**KRISTEN ESTATES  
MINOR SUBDIVISION**

**LETTER OF INTENT  
PCD FILE NO.: SF2521  
August 7, 2026**

KRISTIN ESTATES
EL PASO COUNTY, COLORADO
CONSTRUCTION DOCUMENTS
SITE PLAN

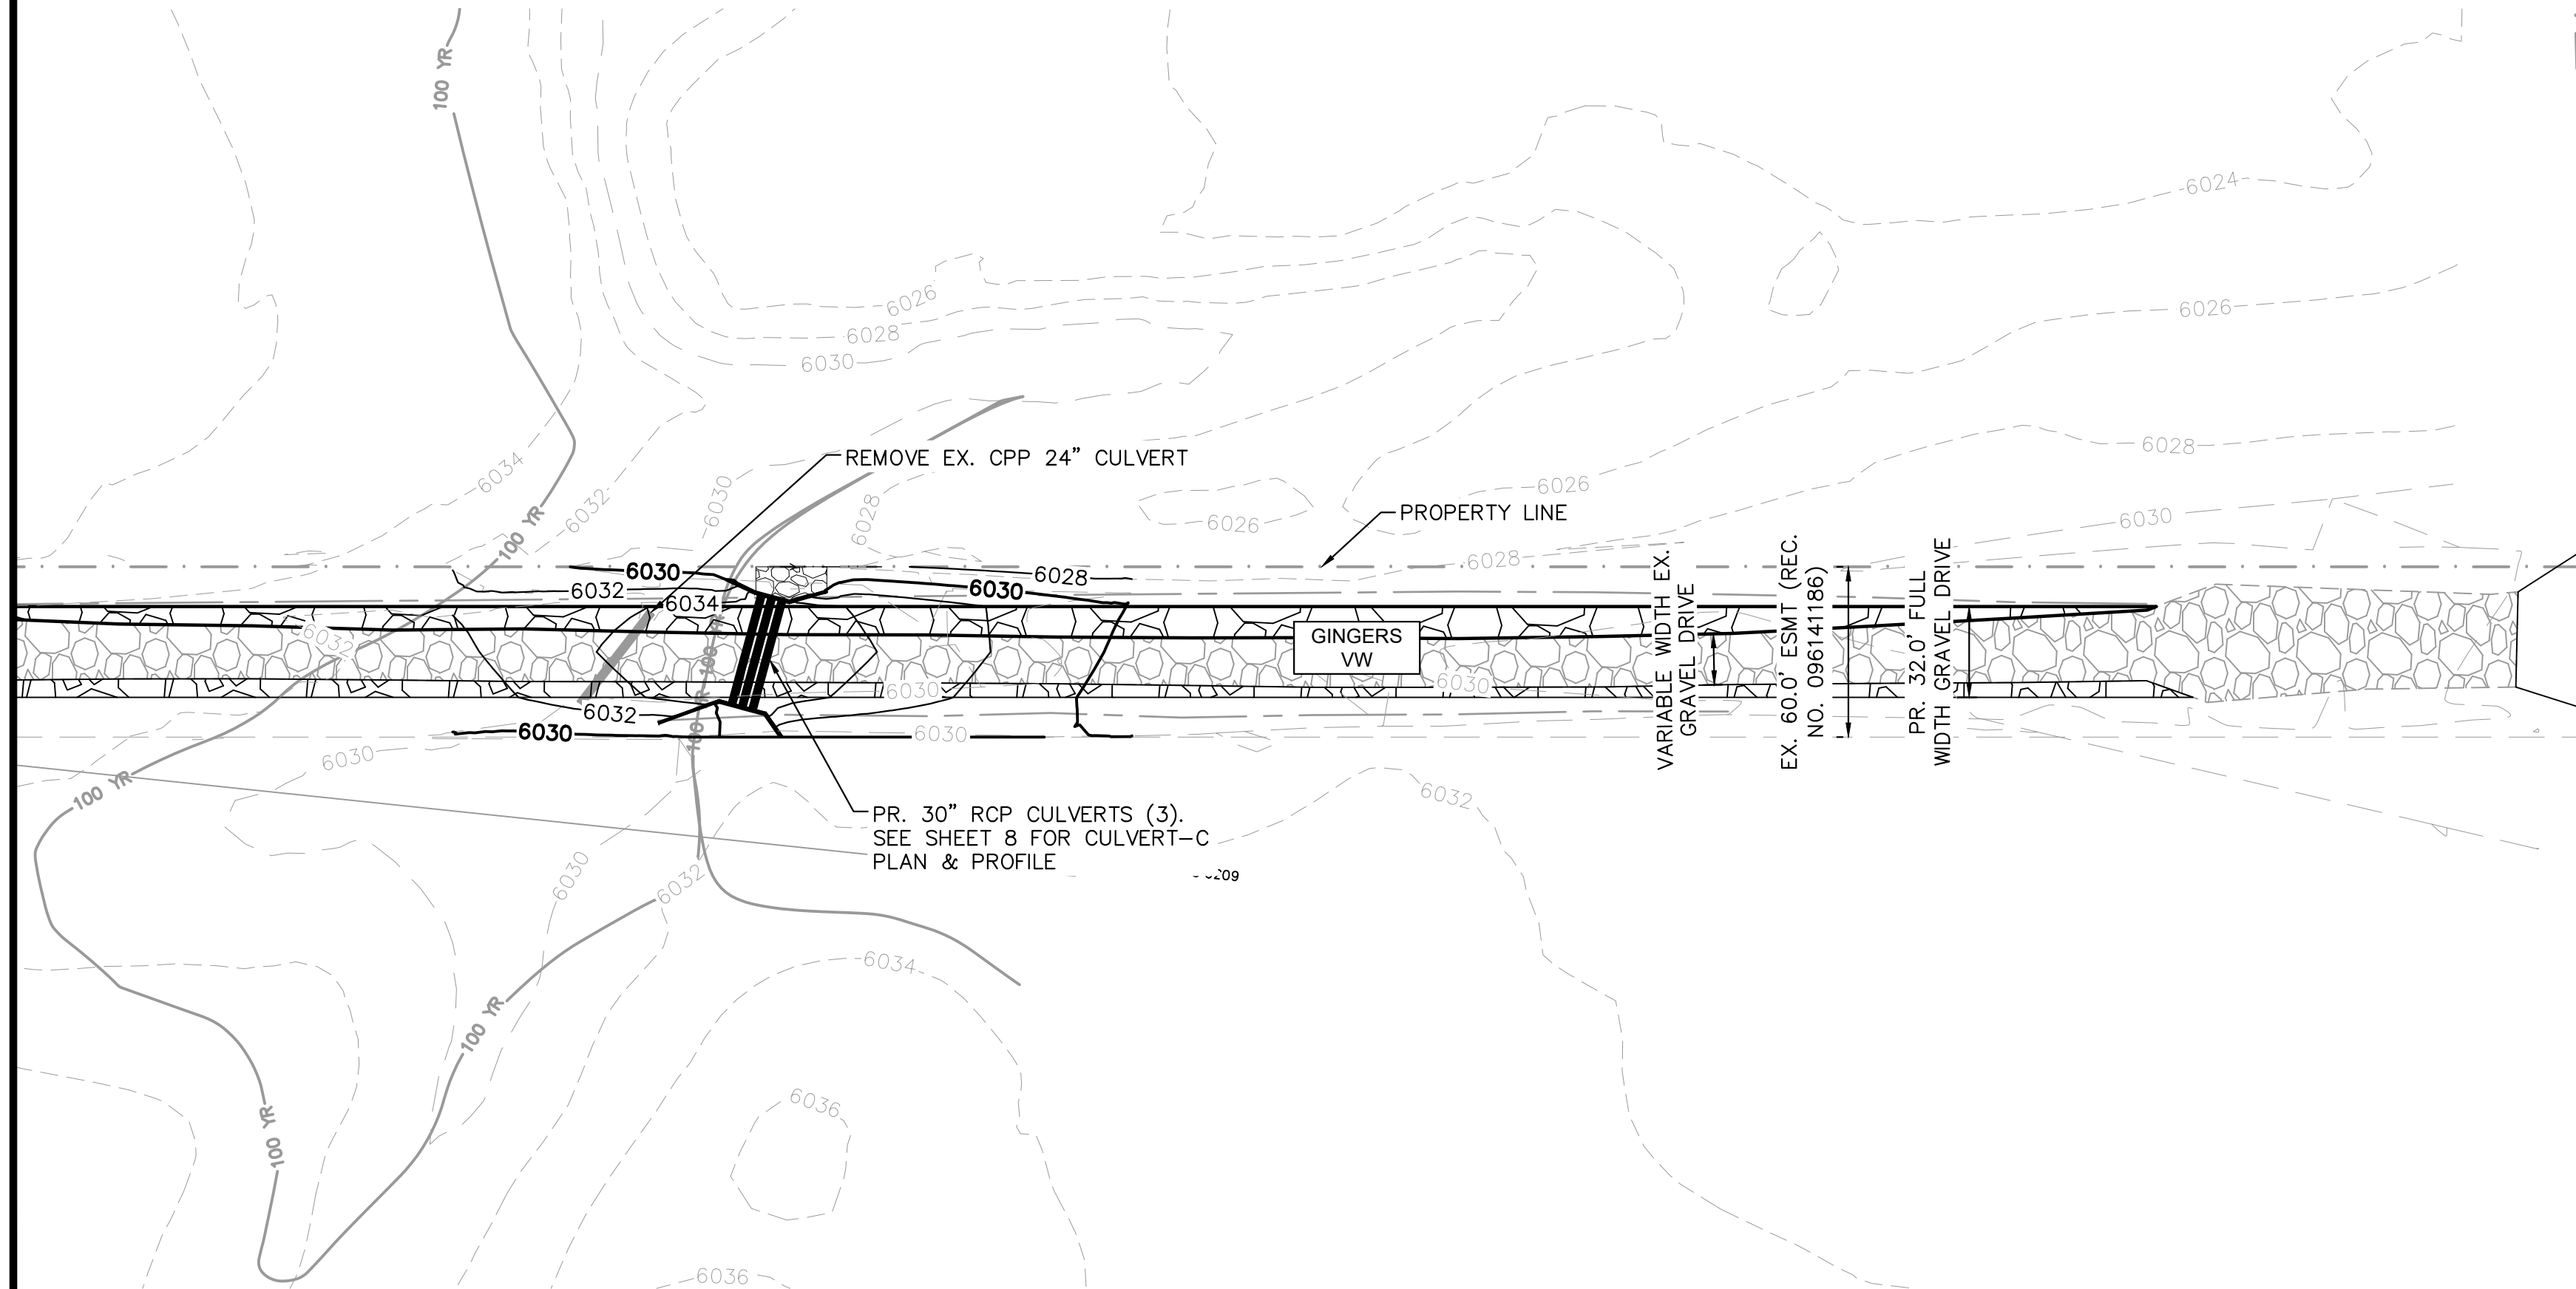
Please be specific: which lots will contain the existing homes. The current zoning does not permit a single lot with two residential dwellings unless one of the homes is converted into an ALQ. (if that is the intent please be specific and let JoeLetke@elpasoco.com aware so I can create you an application)

V1 Comment: In V2 please provide a site plan showing the structures and setback distances. Please note RR-5 only permits 1 principal residence.
